**State Significant Development – Secretary’s Environmental Assessment Requirements  
Swire Cold Storage Facility (SSD 6799)**

<b>Application Number</b>	SSD 6799
<b>Development</b>	Construction and operation of an automated cold storage warehouse and distribution facility including: <ul style="list-style-type: none"> <li>• earthworks;</li> <li>• 33,000m<sup>2</sup> of cold storage space;</li> <li>• warehousing and distribution;</li> <li>• ancillary office space;</li> <li>• infrastructure and services; and</li> <li>• site landscaping.</li> </ul>
<b>Location</b>	Sydney Business Park, Hollinsworth Road, Marsden Park Industrial Precinct, Blacktown Local Government Area
<b>Applicant</b>	Swire Cold Storage Pty Ltd
<b>Date of Issue</b>	December 2014
<b>General Requirements</b>	<p>The Environmental Impact Statement (EIS) for the development must meet the form and content requirements in Clauses 6 and 7 of Schedule 2 of the <i>Environmental Planning and Assessment Regulation 2000</i>. In addition, the EIS must include a:</p> <ul style="list-style-type: none"> <li>• detailed description of the development, including: <ul style="list-style-type: none"> <li>– need for the proposed development

Discipline	GENERAL
Drawing No.	2520460-96-0-502
Rev.	B

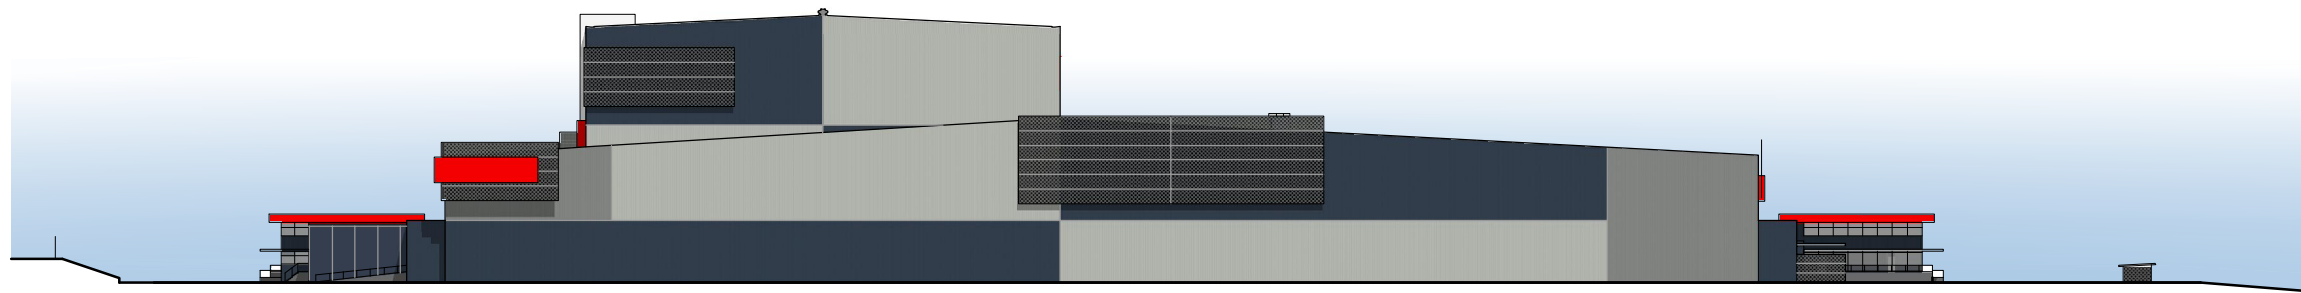
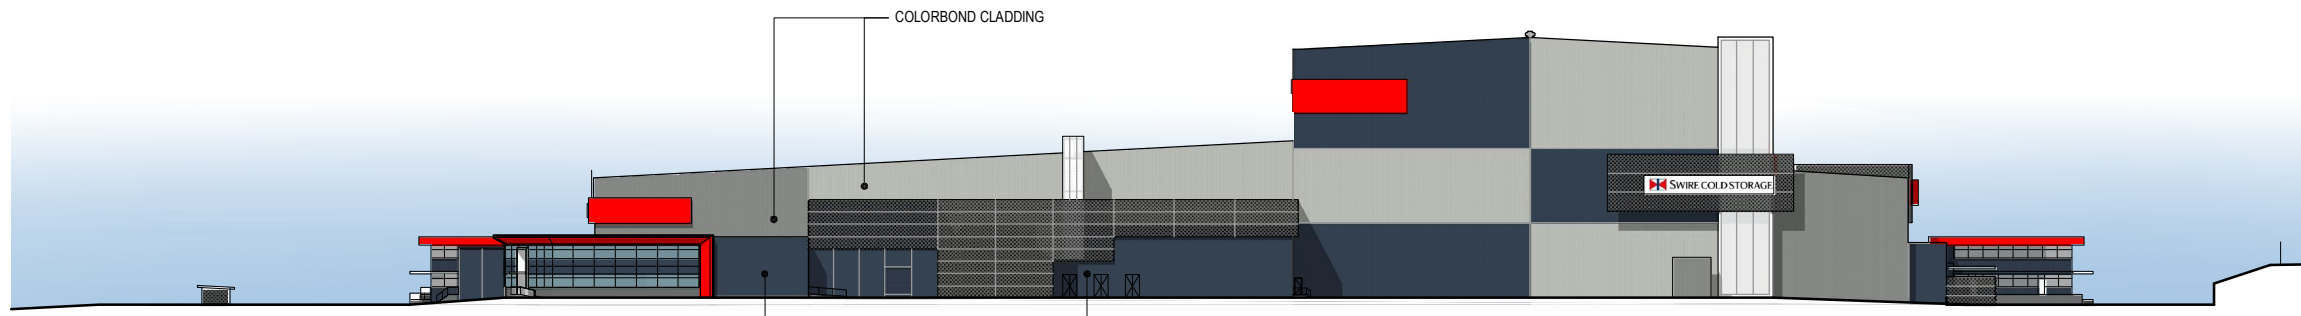
9. Details of screening to all tanks that are proposed to be visible to a public road / place.
10. Full details of external finishes and colours including photomontages. Council is very concerned at a lack of architectural merit and treatment to the 33m high building. The plans provide no mix of colours and finishes. The colours are considered to be too dark and will impact on the skyline.

Particular concern is raised with the elevation to Hollinsworth Road, which is a major collector road, the elevation is unacceptable in its current form as it just a 'shed' with no mix of finishes, the building should have some masonry elements.
11. Full details of all boundary fencing.
12. Any external storage areas are to be fully screened to the full height of the goods to be stored. Any screening of storage shall not impede sight distances for trucks or vehicles.
13. Concerns are raised regarding the "empty pallet" areas located towards Hollinsworth Road. No storage of any goods is to be permitted within the setback to Hollinsworth Road.
14. Details of any retaining walls including materials of construction.
